RE – Application Number SSD-70748466 – Huntlee Town Stage 2

We are writing to you regarding the development application Huntlee New Town – Stage 2 (application number SSD-70748466) at North Rothbury.

We wish to object to the planned intersection A-8 located along Wine Country Drive between Hanwood Road and Mayne Street North Rothbury.

DRAWING TITLE CONCEPT CIVIL ENGINEERING PACKAGE INTERSECTION A-8 - VEHICLE SWEEP PATHS PLAN - SHEET 2

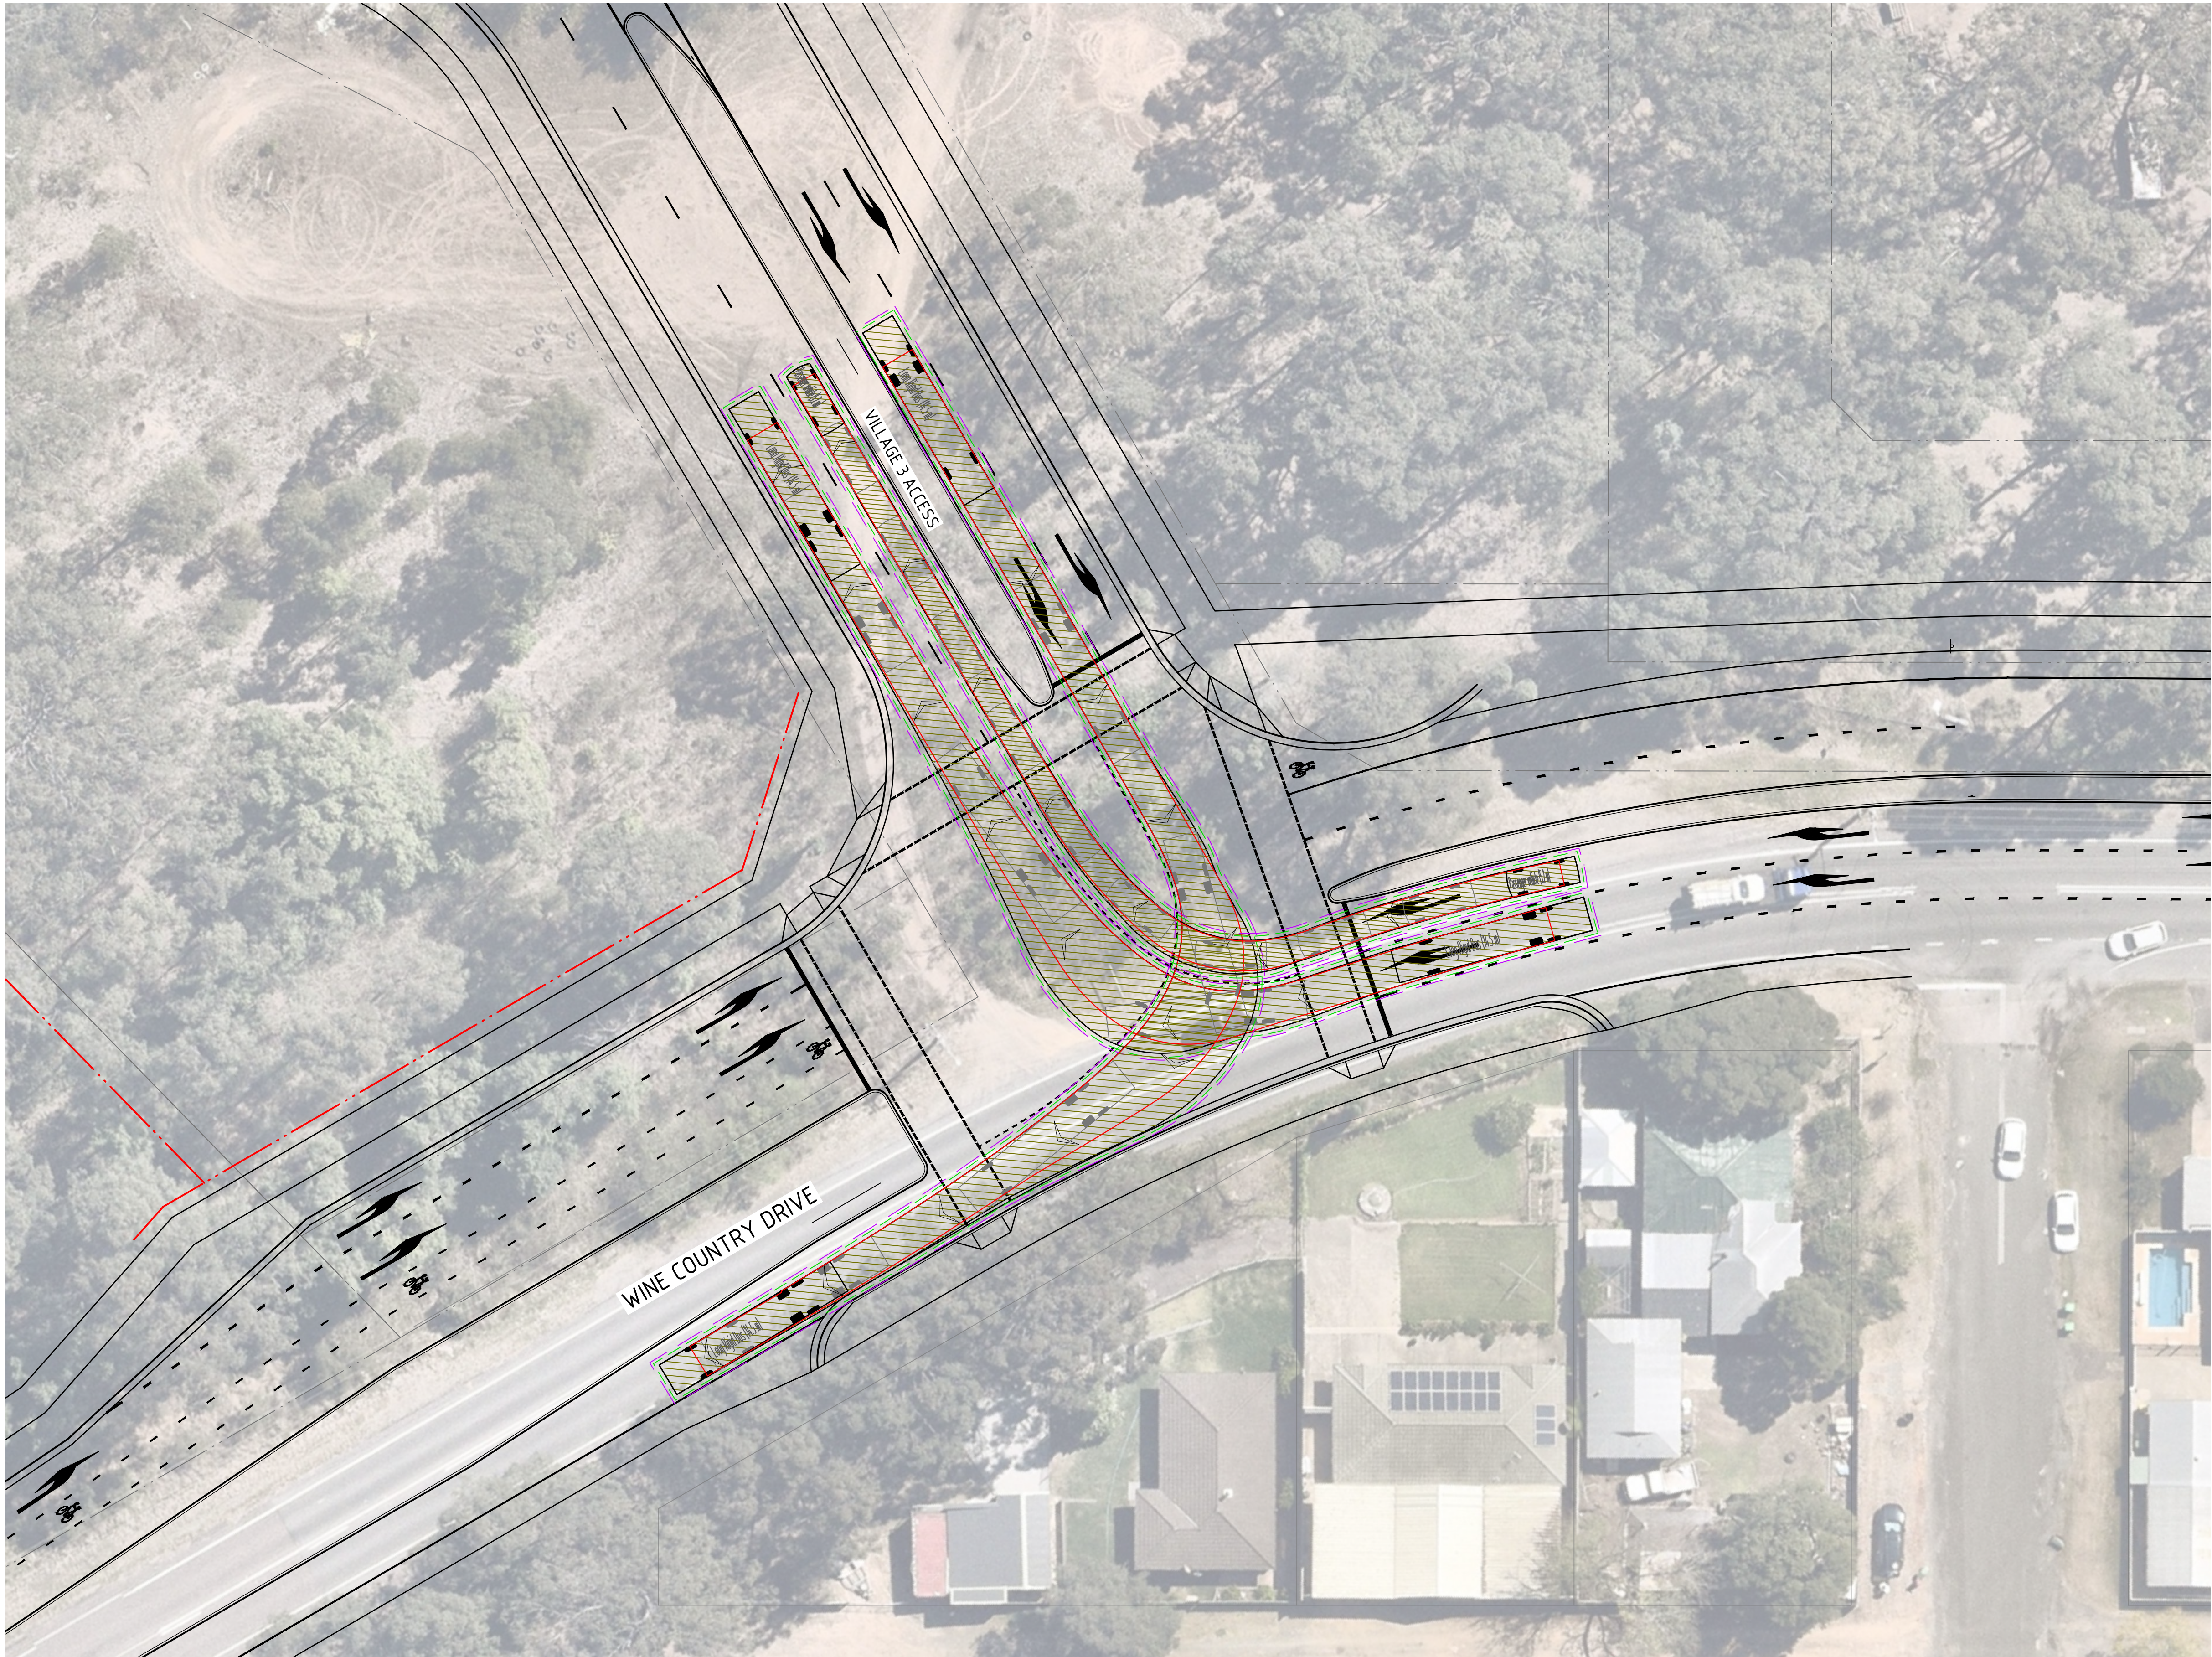
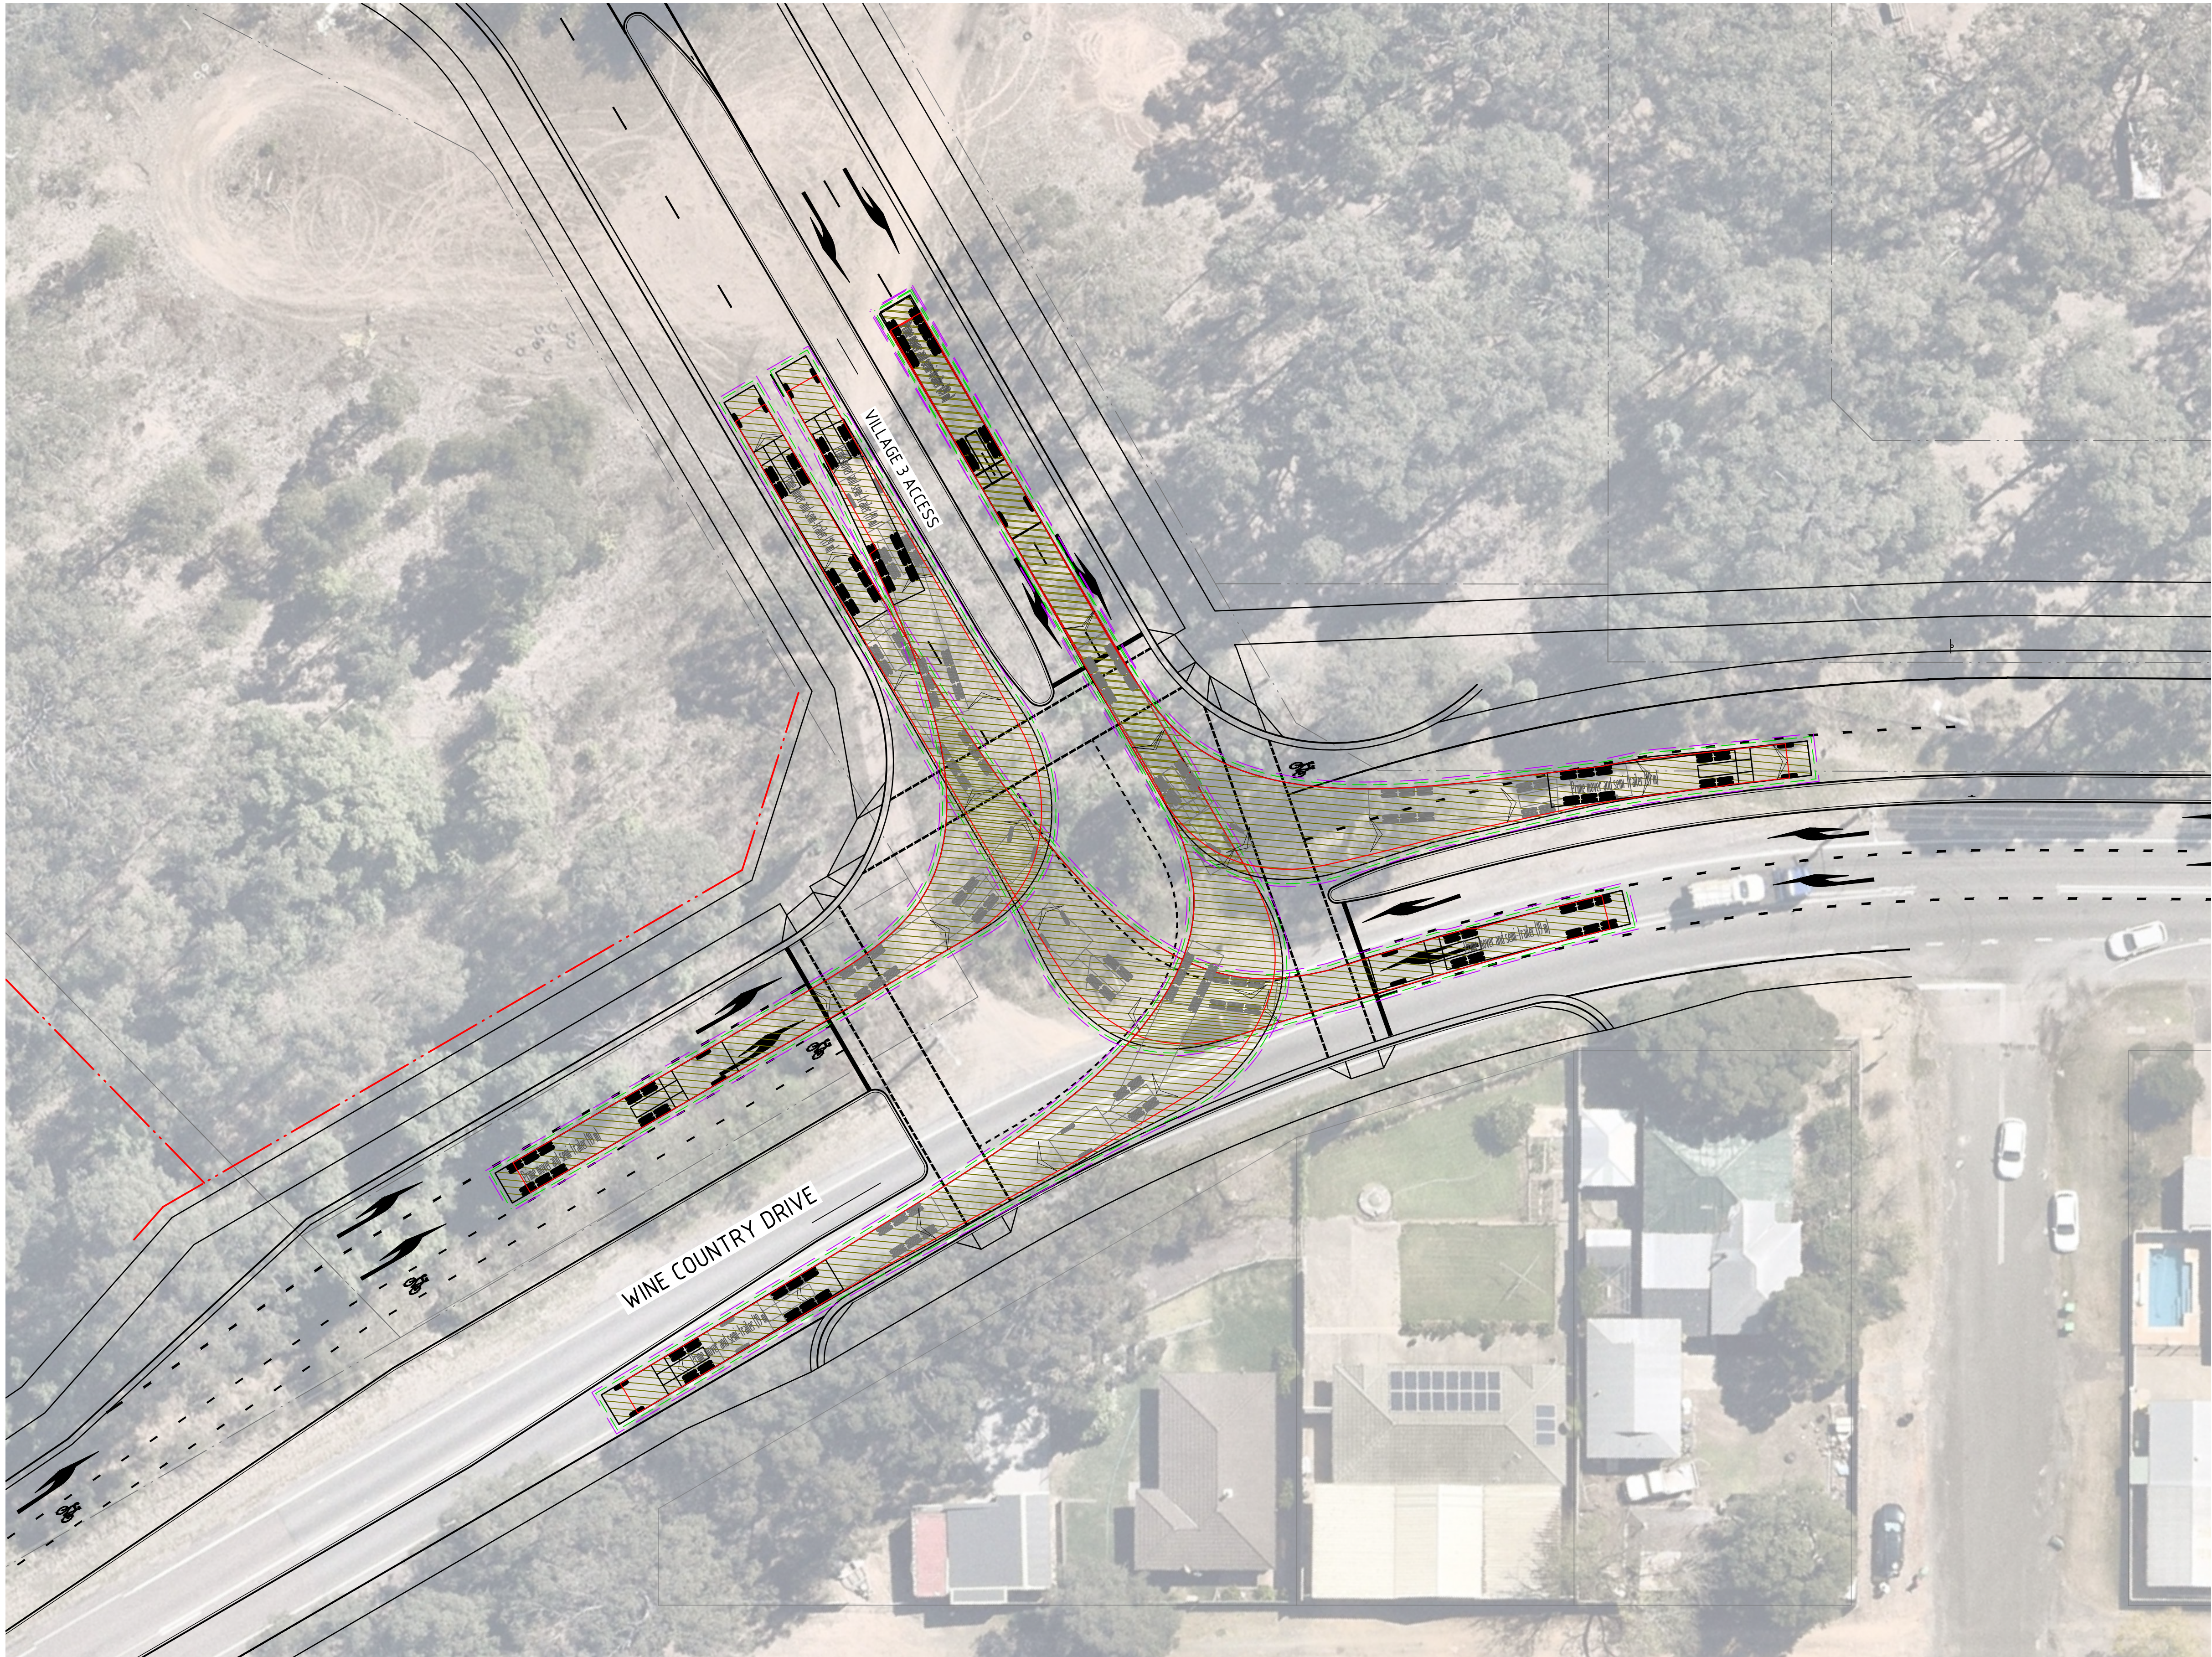
I believe this intersection development proposed within the Stage 2 application will have a detrimental effect on the property located directly adjacent to the proposed intersection therefore have several issues that need to be addressed.

- No traffic computer modelling undertaken on existing property driveway connecting to new/upgraded roadway.

The new/upgraded roadway does not indicate if left or right turns are allowed travelling in directions north and southbound for entry and exit of the property. This warrants an impact of unknowns and a potential safety hazard of the development.

- Loss of security and privacy due to motorist stopping at traffic signals.
